### RE: Rogers Short Plat (SP-06-43)

The Kittitas County Community Development Services Department has determined that the Rogers Short Plat is a complete application and hereby grants **conditional** preliminary approval subject to the following conditions:

CRUSE & ASSOCIATES
PROFESSIONAL LAND SURVEYORS
217 E. Fourth St. P.O. Box 959
Ellensburg, WA 98926 (509) 962-8242
ROGERS SHORT PLAT

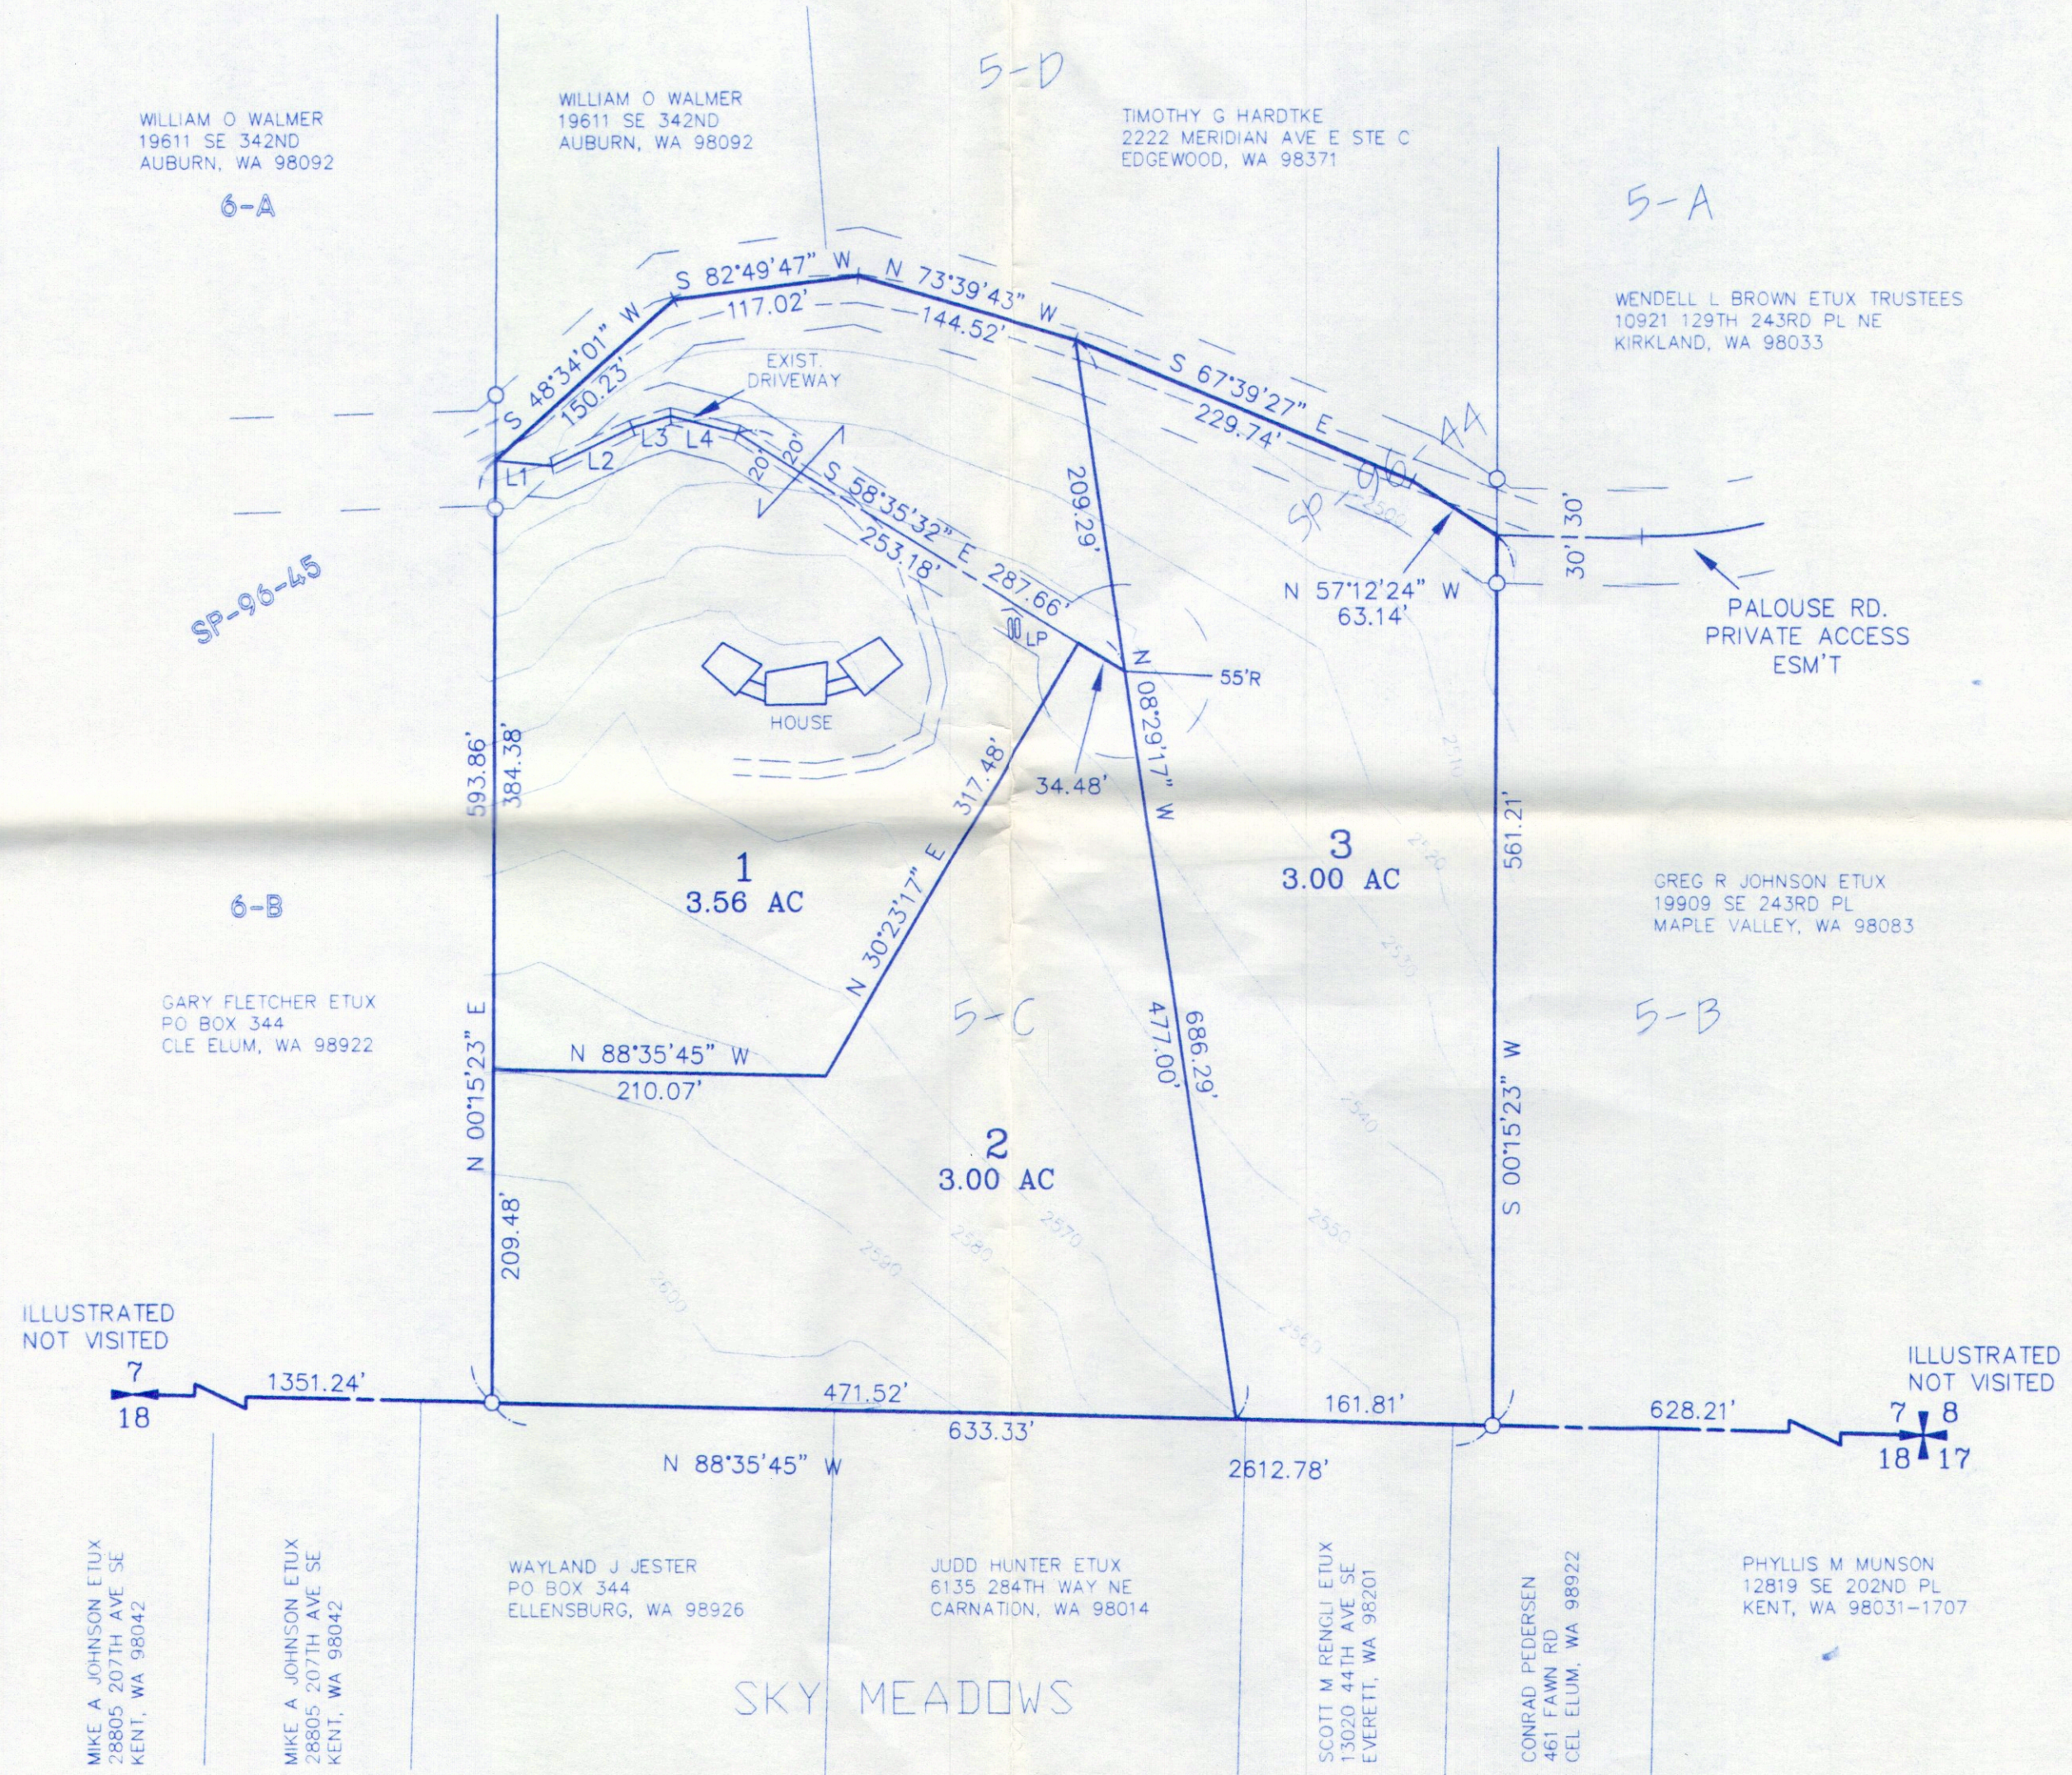
1. Both sheets shall reflect the short plat number SP-06-43.
2. In the future, if the county deems necessary, the current owners of said property will provide a 60' right away for the location of a county road in the location of the existing easement shown on the face of the plat for the development of future road systems.
